# 461 CHAPEL ROAD

BANKSTOWN 2200

DESIGN REVIEW REPORT

07 / 04 / 2025

DESIGN OUTCOME
GROUND FLOOR PLAN

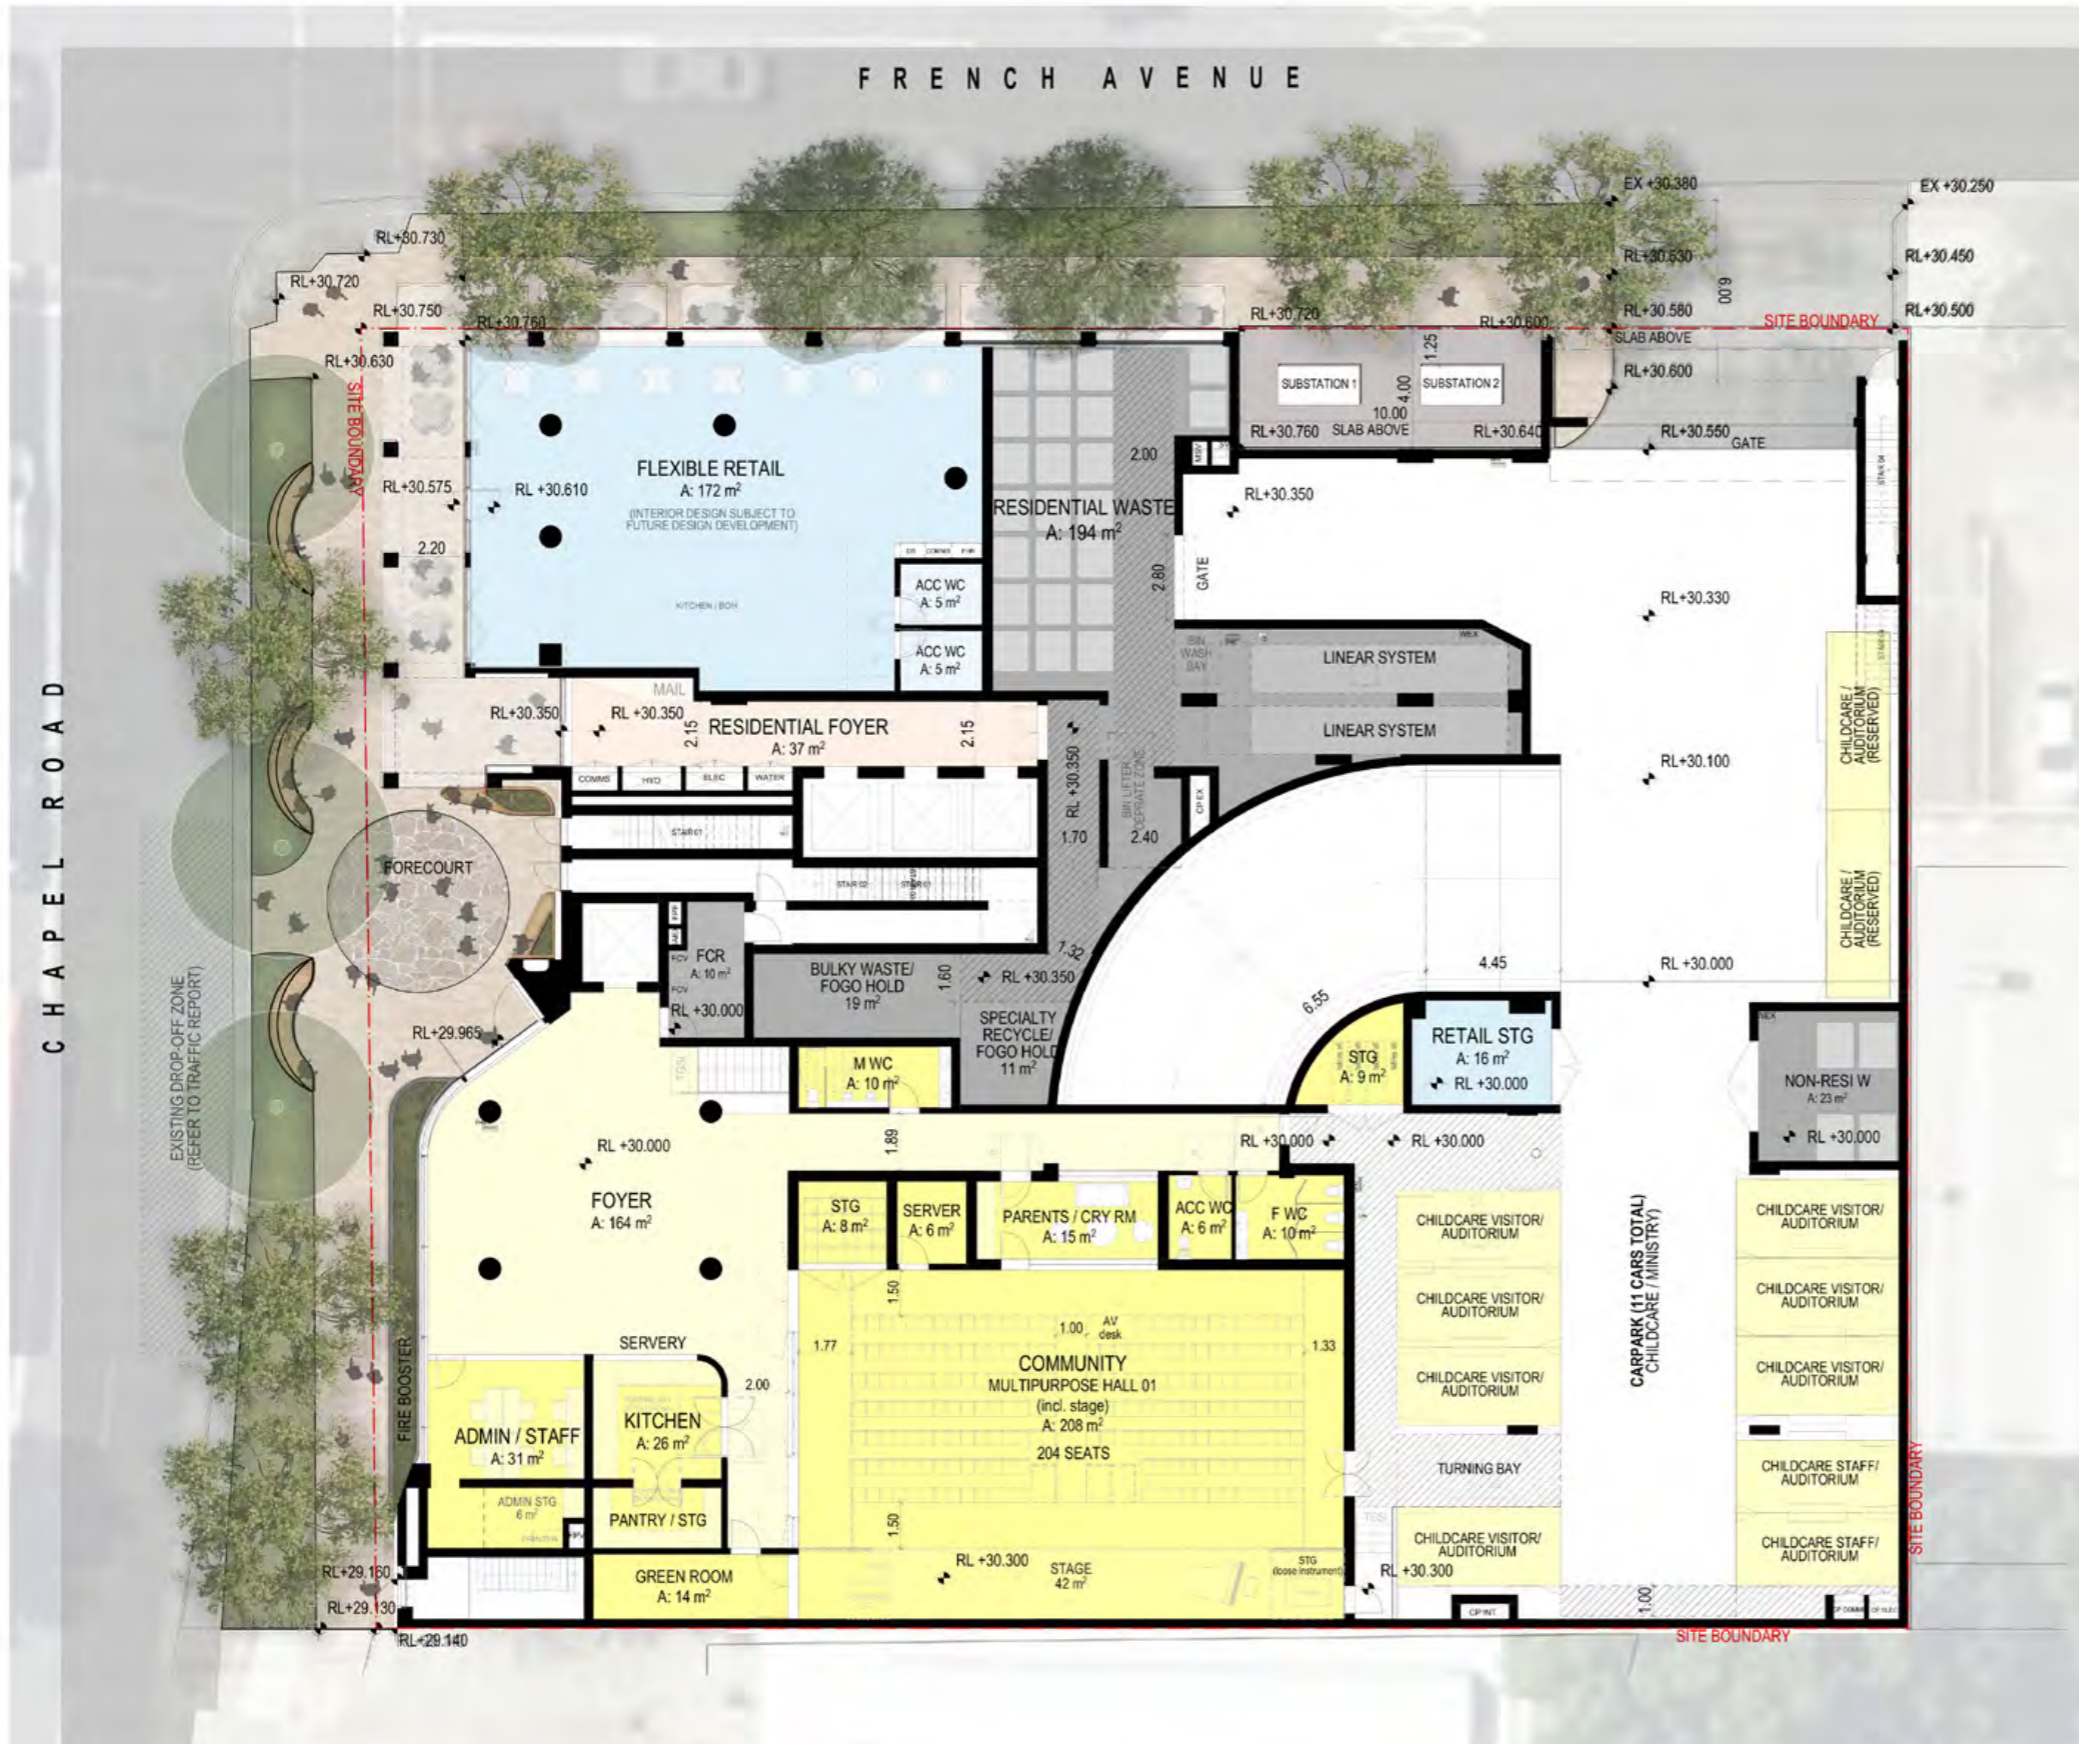
Provide more generous space to the Chapel Road frontage to reinforce its civic role and encourage community gathering e.g. a colonnade to define the street and provide various spaces for gathering.

Set back the retail to protect outdoor dining from pedestrians and integrate weather protection e.g. colonnade or continuous canopy

Increase the extent of activation on French Avenue by rationalising services and waste

In response to the SDRP feedback the proposal was amended to push the retail back create a colonnade at the corner of Chapel Road and French Avenue that will provide additional area for pedestrian movement and gathering space around the community facility.

a. The proposed awnings have been removed to extend the colonnade further out, facilitating pedestrian mobility and providing protection from all types of weather. The existing trees along Chapel Road will be retained and offer canopy cover to provide shading and further weather protection, whilst offering benefits to the local ecosystem.

The waste room has been rearranged to increase the street activation on French Avenue.
